From: Anita Gardner <Anita.Gardner@arun.gov.uk>
Sent: 25 February 2021 17:32
To: Planning.Responses <Planning.Responses@arun.gov.uk>
Subject: FW: Planning Consultation on: CM/53/20/PL
Importance: High

From: Kerry Simmons [REDACTED]
Sent: 15 February 2021 14:54
To: Anita Gardner <Anita.Gardner@arun.gov.uk>
Subject: Planning Consultation on: CM/53/20/PL

Engineers Comments Regarding Surface Water Drainage

SITE PLAN
SCALE 1:500 @ a3

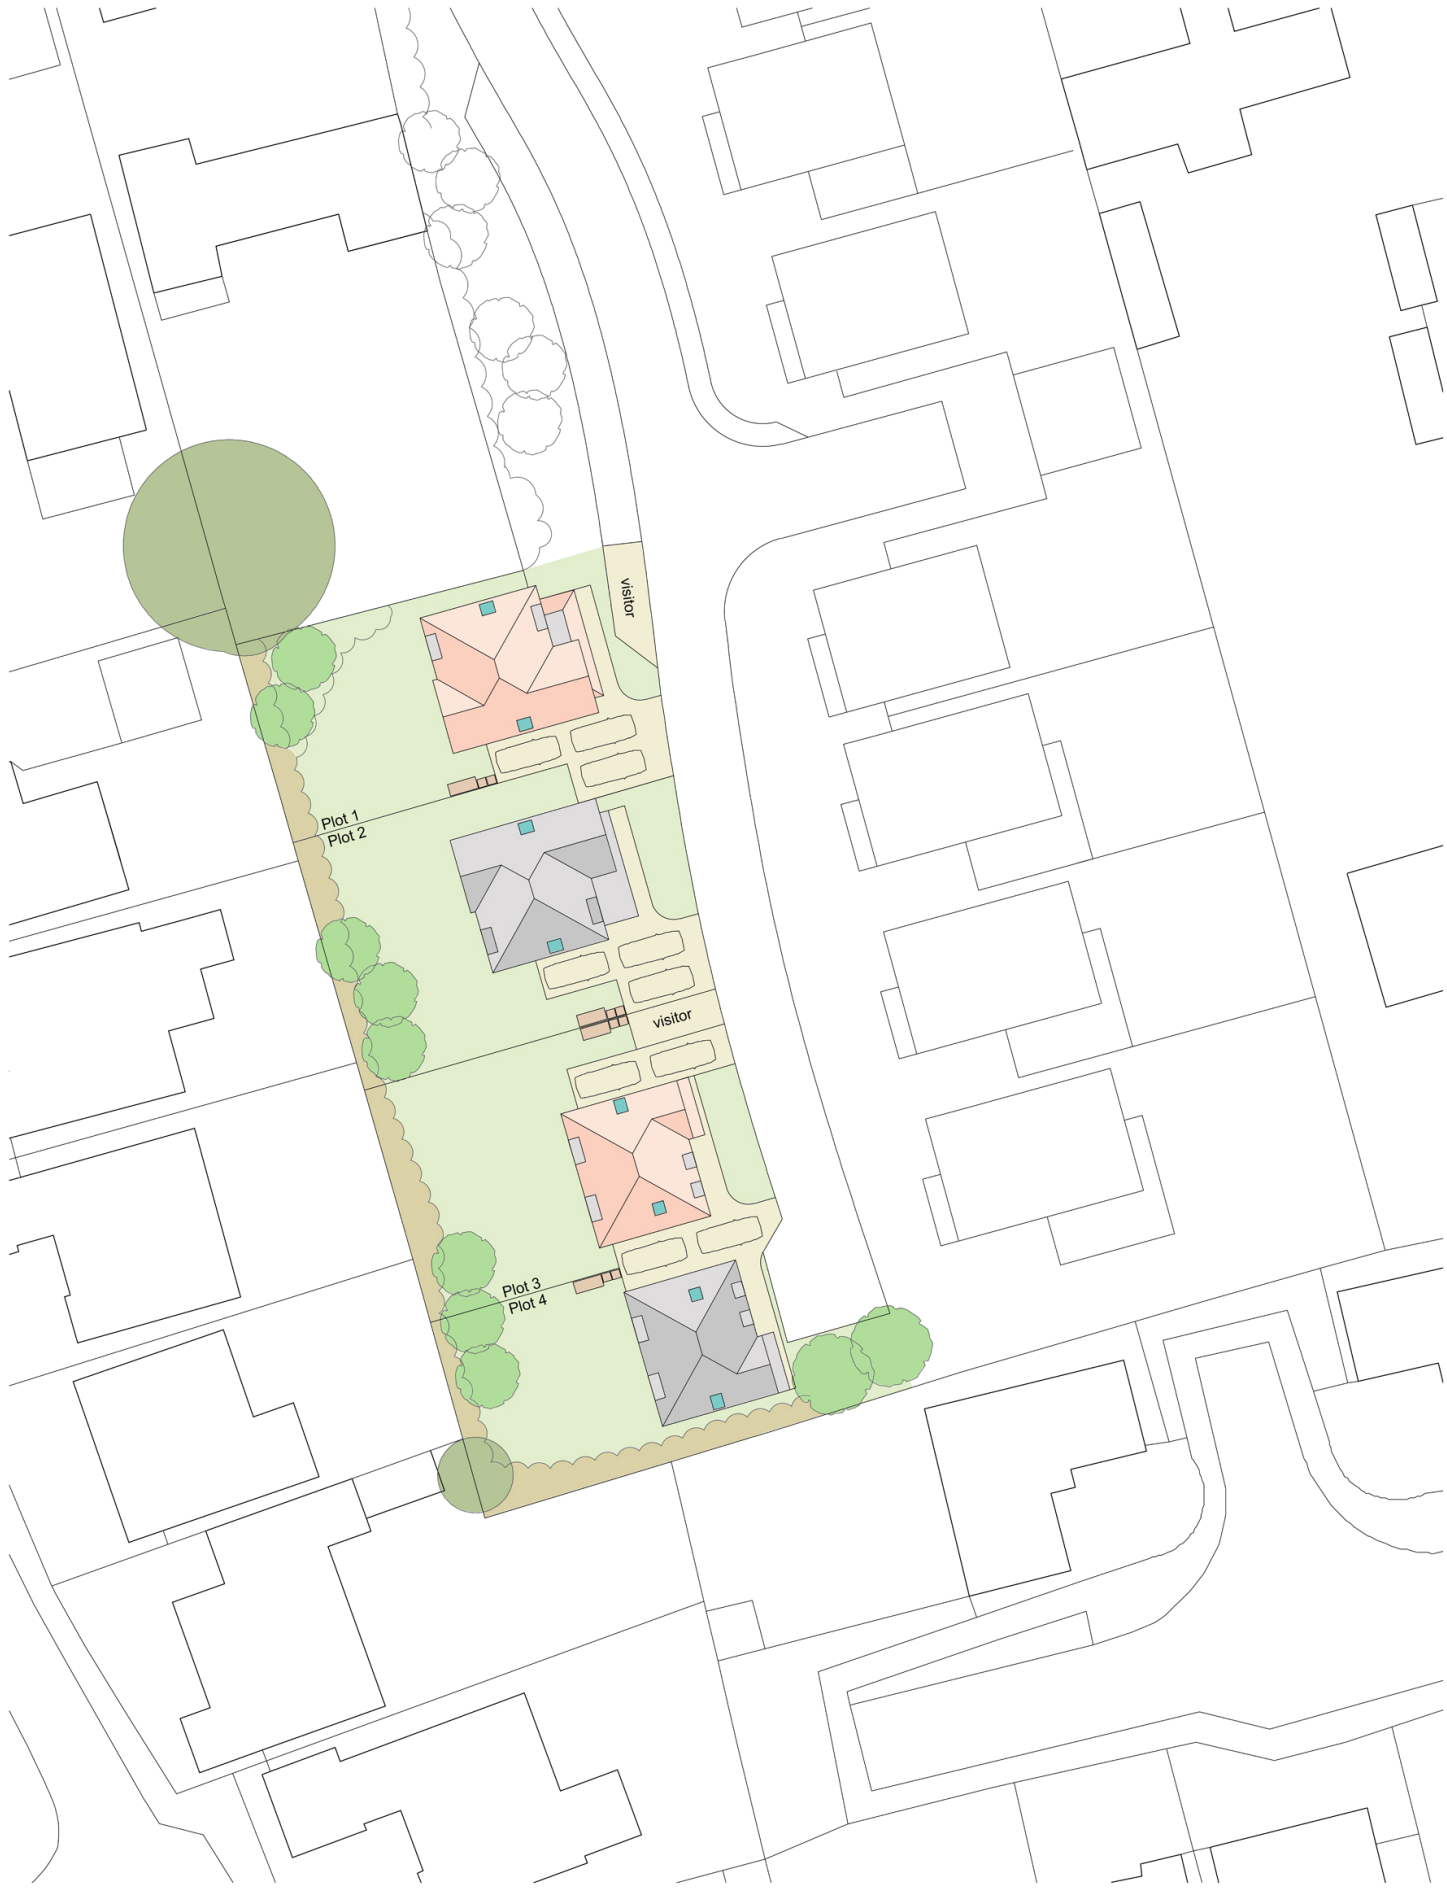
Without prejudice to the requested withdrawal of this application I would re-iterate that there are concerns regarding the proximity of the proposed dwelling at plot 4 to the side boundary with 30 Appletree Walk. The 45 degree rule is accepted as more relevant to an extension setting, but it serves to demonstrate that the outlook from rear windows is important and is a base for assessing these relationships. The Design Guide includes a section on backland development which is also relevant and states 'Backland developments should demonstrate an understanding of any potential effects on the character and amenities of the neighbouring urban area. As a general rule, backland developments should be subservient to existing properties, and their layout should seek to maximise the outlook of neighbours. Proposed building scales and development densities should address the characteristic urban development patterns of previous backland developments in the area.'

Plot 4 does not accord with this guidance. It cannot be described as maximising outlook or subservient given its height and proximity to the boundary. The gap to the boundary should be dimensioned and increased, or the height of the dwelling reduced adjacent to the boundary. In my view, although the garden to no 30 may receive an acceptable amount of sunlight/daylight from the south and west the dwelling would have an overbearing impact on the users of this garden since it extends to approximately half of the garden length.

Plot 2: requires only a minor adjustment to the footprint – this work is underway and will further inform the tree survey.

Plot 4: we would like to clarify whether the 45 degree rule is strictly relevant to the relationship between plot 4 and the neighbouring property at 30 Apple Tree Walk; there would be a significant gap between the rear of no. 30 and the proposed house at plot 4 as shown on the extract site plan below. Our understanding of the 45 degree rule is that it applies where there the development would result in a continuous built form along the side of an existing dwelling, and is traditionally applied to assessing the impact of an extension on an existing dwelling. Due to the orientation of the properties no. 30 will continue to receive uninterrupted sunlight/daylight from the south and west as the proposed unit is positioned to the north and will also enjoy a large gap between its rear elevation and side elevation of plot 4. Based on this information it is considered that plot 4 would have an acceptable relationship with no. 30 Apple Tree Walk.

Would it be possible to have a quick chat about plot 4? We are looking to withdraw and redesign this plot – potentially to a meaningful 1.5 chalet style wot reduce the eaves on the boundary and move the side elevation off the boundary.
